From: Cherne, Curtis
Sent: Friday, October 22, 2010 2:37 PM
To: Dourte, Richard H.; Cloud, Jack W.
Subject: ICE Site Plan

Re: Certification Submittal for a Permanent Building Certificate of Occupancy (C.O.)
for ICE Facility - Mesa del Sol, [Q-16 / DA0002]
5441 Watson Dr.
Engineer's Stamp Dated 12/22/11

Re: ICE Albuquerque Grading and Drainage Plan and Drainage Management Plan

Engineer's Stamp dated 10-18-10 (Q16/DA0002)

C-010

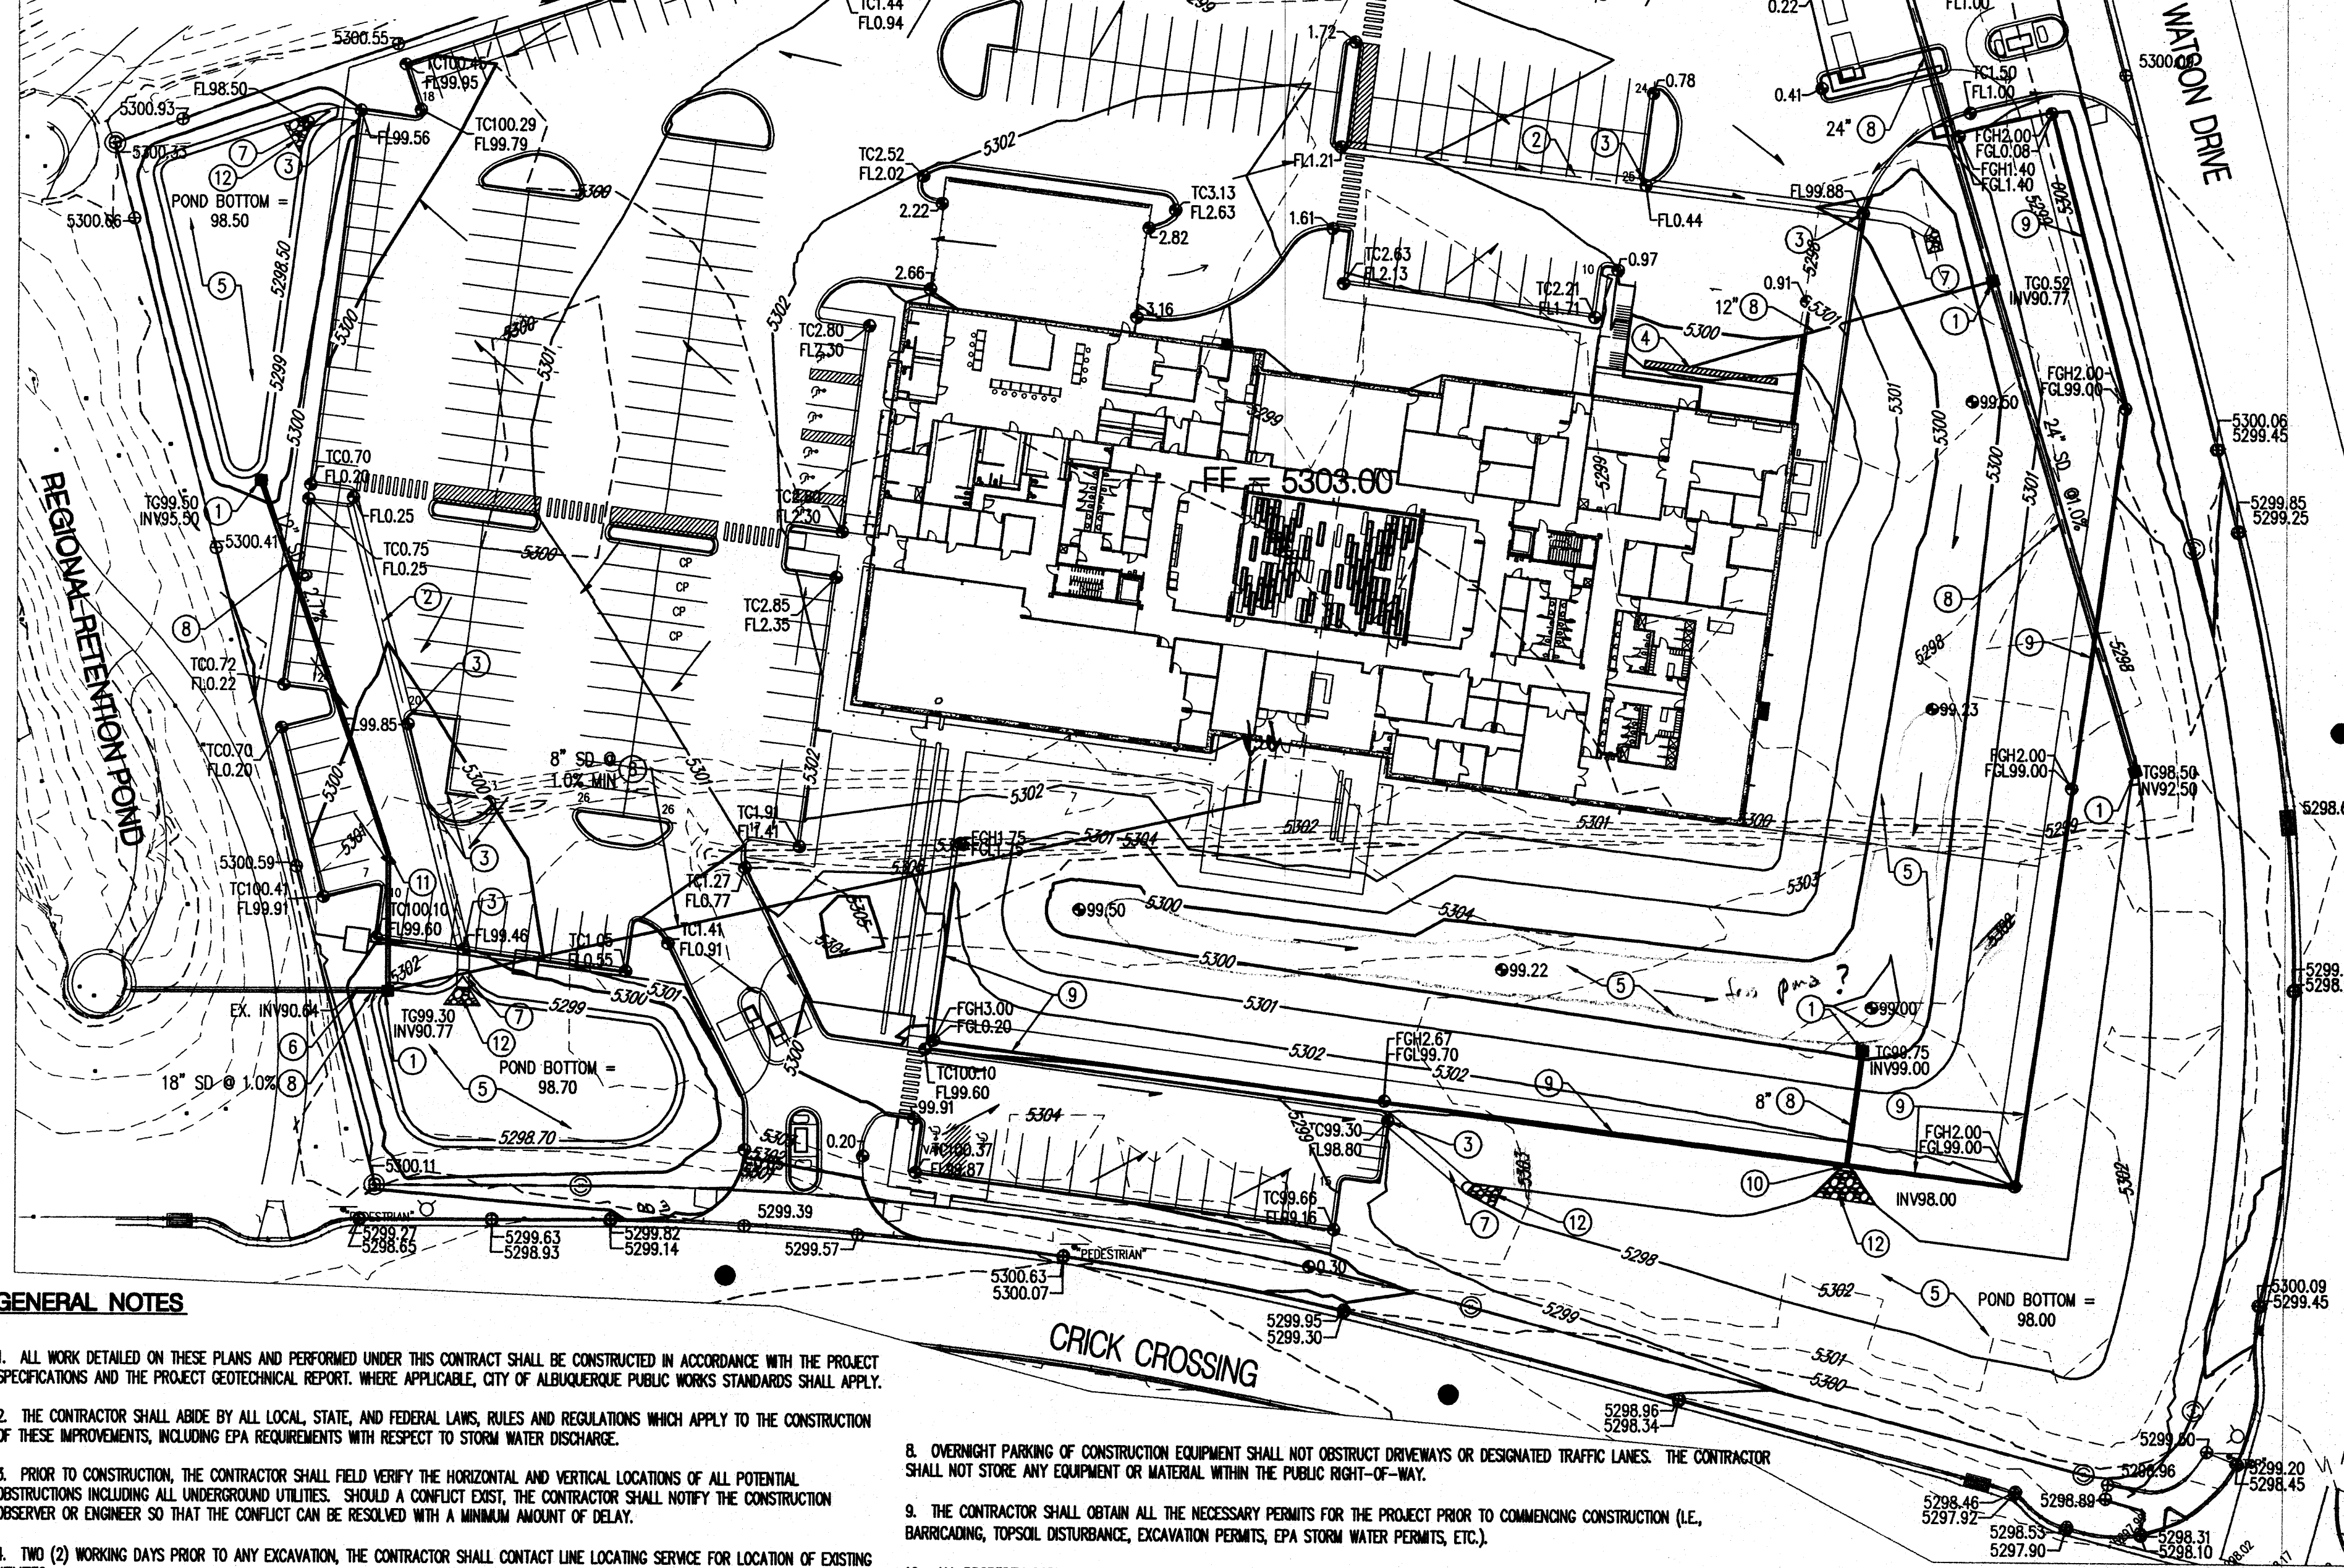
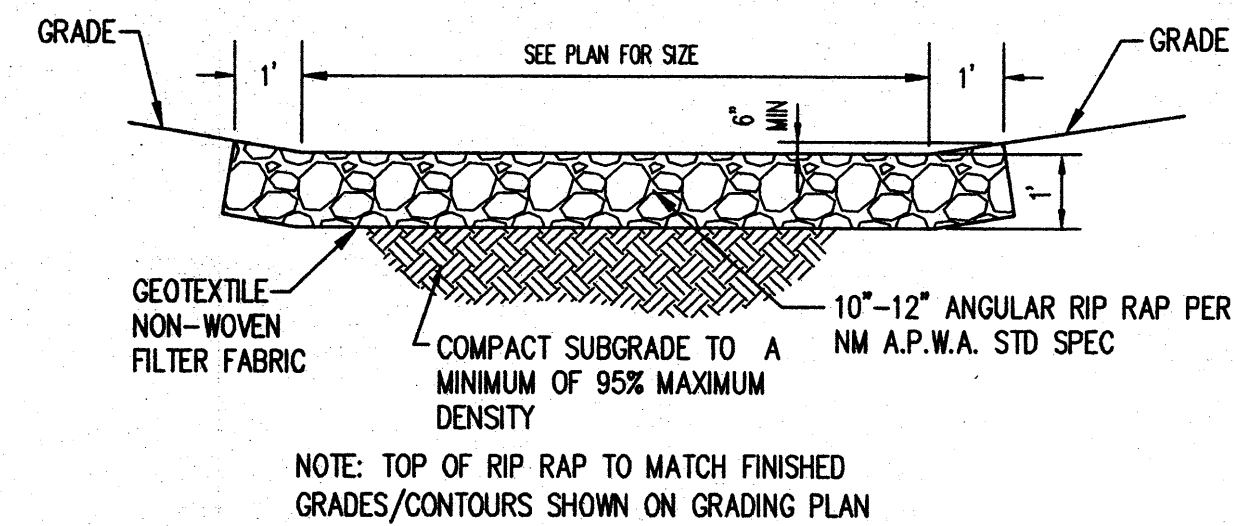
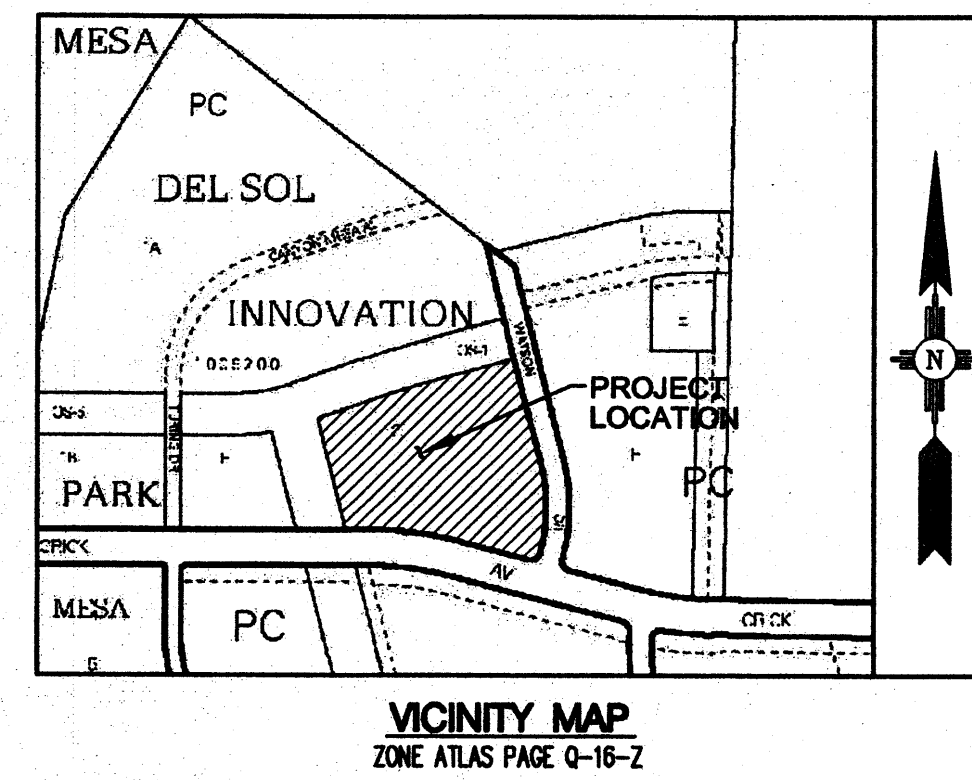
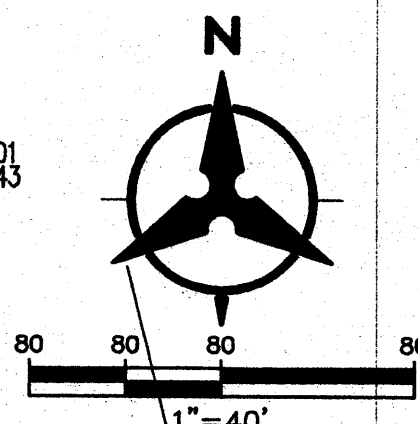
- There are three WHA's labeled "WHA-C2"
- The courtyard inside the building drains to Basin 2, but is shown in Basin 3.
- Detail "3" has a 24" label for the 3' curb opening.
- Provide the Totals for the 6hr-100 yr Flow and Volume in the Basin Table.
